Our Ref: NW/am/PF/10528  
(Please reply to Banbury office)

**TOWN AND COUNTRY PLANNING ACT 1990  
DISCHARGE OF CONDITIONS RELATING TO 22/01144/F**

'Full planning application for the erection of a new high quality combined research, development and production facility comprising of Class B2 floorspace and ancillary office floorspace with associated infrastructure including: formation of signal-controlled vehicular access to the A41 and repositioning of existing bus stops; ancillary workshops; staff gym and canteen; security gate house; a building for use as an energy centre (details of the energy generation reserved for future approval); loading bays; service yard; waste management area; external plant; vehicle parking; landscaping including permanent landscaped mounds; sustainable drainage details; together with the demolition of existing agricultural buildings within the red line boundary; and the realignment of an existing watercourse' .... **At Symmetry Park, Oxford North.**

Further to the submission of the discharge of pre-commencement conditions (LPA Ref; 23/00415/DISC) and (23/00417/DISC) at Symmetry Park Oxford, comments have now been received from the Environment Agency

drawing title	Detailed Landscape Proposals	Sheet 1 of 17
date	18 OCTOBER 2022	drawn by LCH
drawing number	edp2425_00171	checked BC
scale	1:1500 @ A0	QA RB

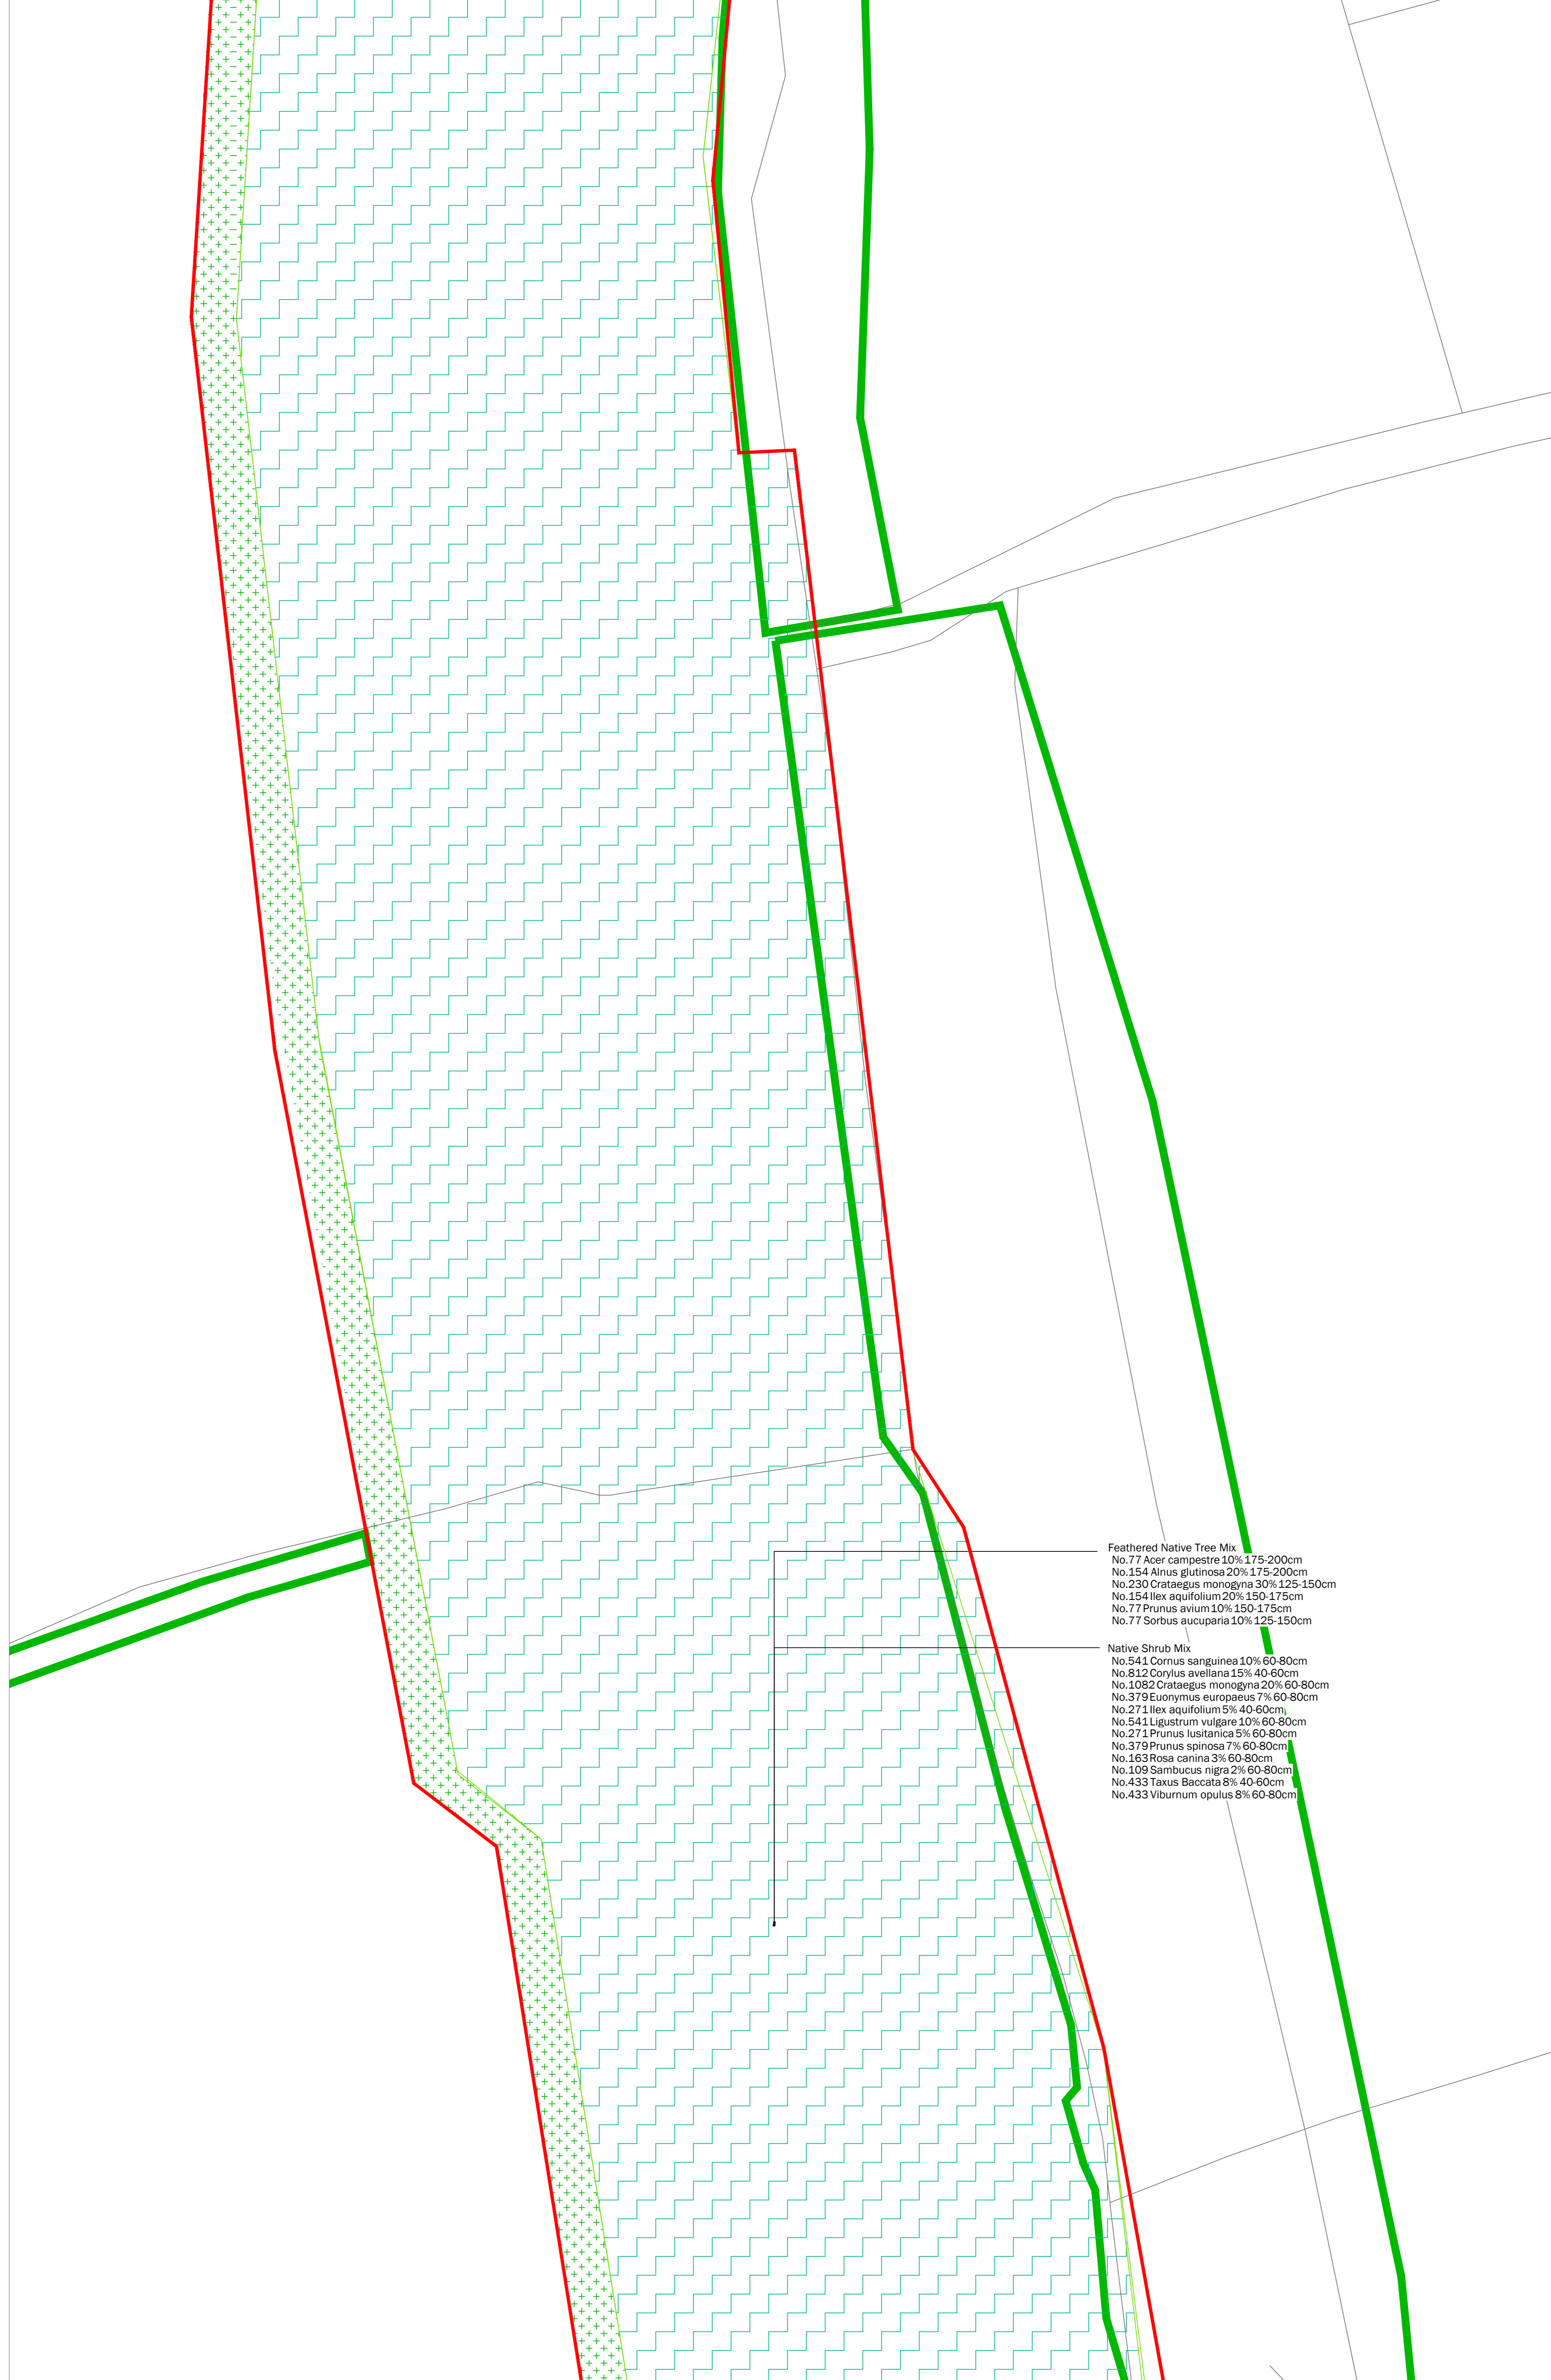
- *There is no sheet to cover the furthest extent of the brook before it crosses the main road (i.e., Northeast of sheet 7). The LEMP should cover the maintenance of an ecological buffer zone for the entire length and both banks of the watercourse where it is not culverted.*

No amendments are proposed to the watercourse (which remains on its existing route) to the north of the new estate road. Details of this are shown on Sheet 1 of 17, with a continuation of the proposed species-rich meadow grass between the southern side of the watercourse and the A41 boundary and existing hedgerows being clearly shown. Again, these are matters that were shown on

the detailed Landscape Plans approved as part of the determination of the original application, and form the basis on which planning permission was granted.
